**Re: Desert Springs Church – 705 Osuna Rd. NE  
Erosion and Sediment Control Plan  
Engineer's Stamp Date (missing) (E16E021)**

Based upon the information provided in your submittal received 1/14/2022, the above-referenced ESC Plan can't be approved until the following comments are addressed.

TESCP

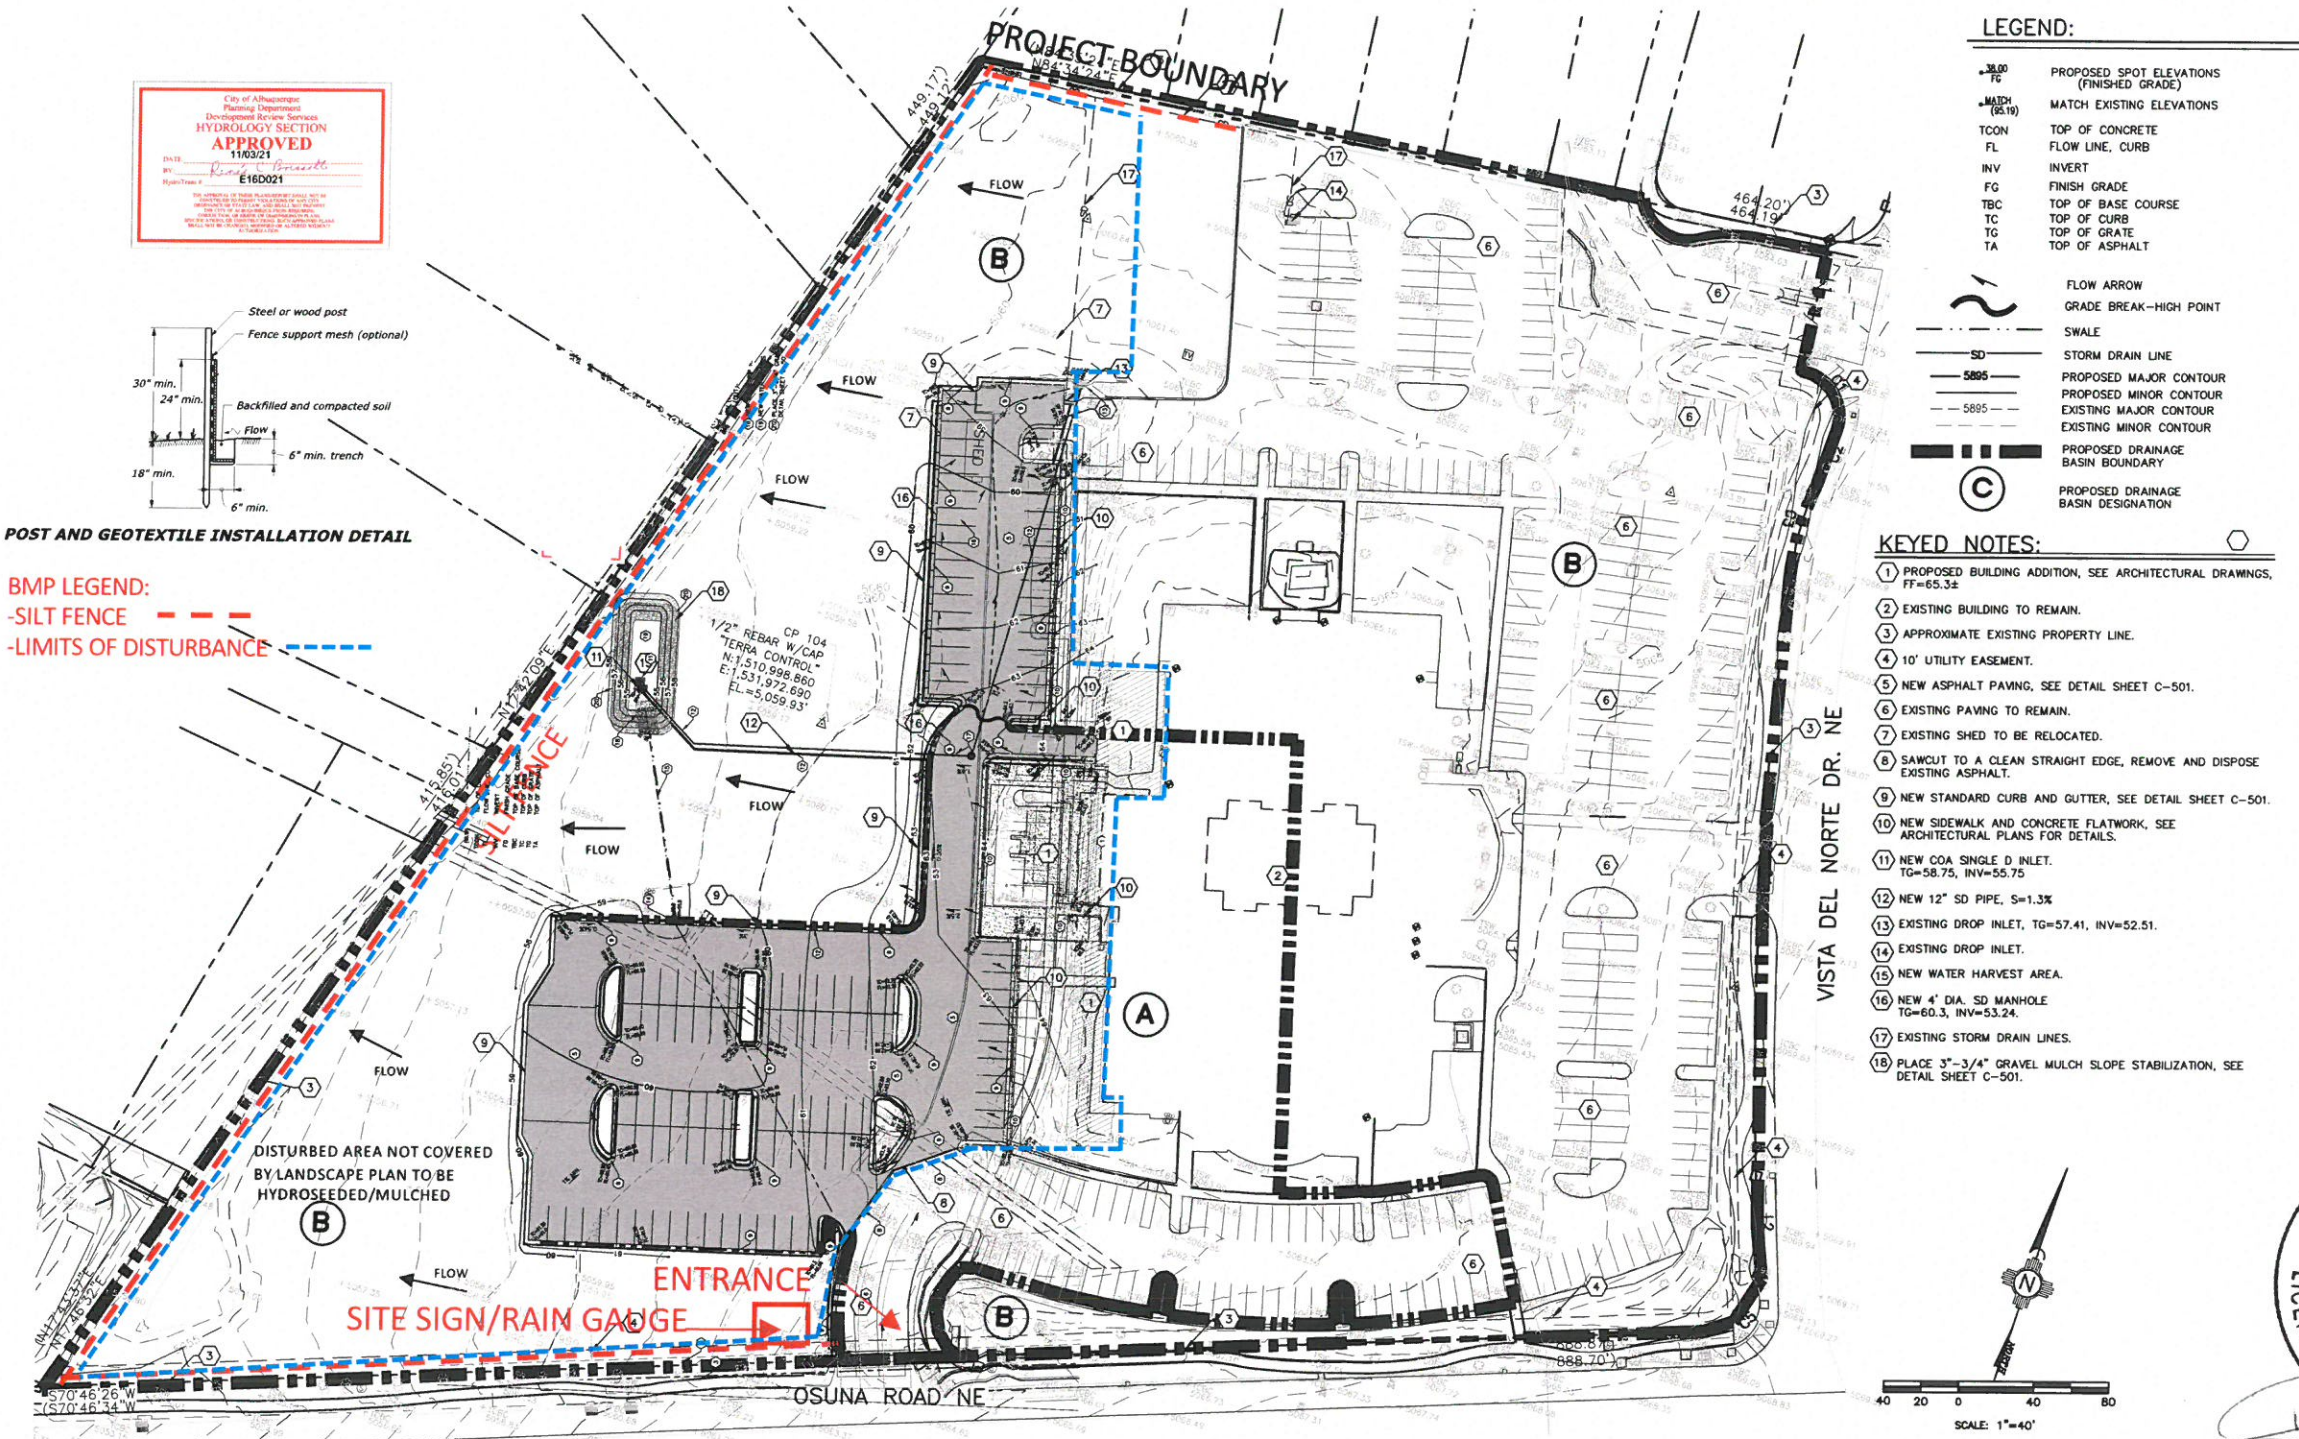
1. The grades shown on the ESC Plan must match the grades shown on the approved G&D Plan (missing).
2. The professional certification is missing from the plan that was submitted. The ESC Plan must be certified by a New Mexico Registered Professional Engineer (PE) or a Certified Professional in Erosion and Sediment Control (CPESC).

3. The limits of disturbance must be shown accurately (missing).
4. The SWPPP must include site-specific interim and permanent stabilization per CGP 9.4.1.c.i. The landscape plan can be used to satisfy this requirement and should be included in the SWPPP and the ESC Plan submittal. Also provide a specification for any disturbed areas not covered by the Landscape Plan.

5. List operators on the plan, including name, phone #, and e-mail address.
6. Identify stormwater team members:
  - a. Personnel who are responsible for the design, installation, maintenance, and/or repair of stormwater controls (including pollution prevention controls);

8. Soil information – add a table with name type, particle sizes, and Erodibility factor (CGP 2.1.1).
9. Vicinity map – add a zone atlas map clearly indicating location and street names.
10. City Standard ESC Notes are required on the ESC plan (attached).
11. Update the engineer's stamp date each time the plan is changed.
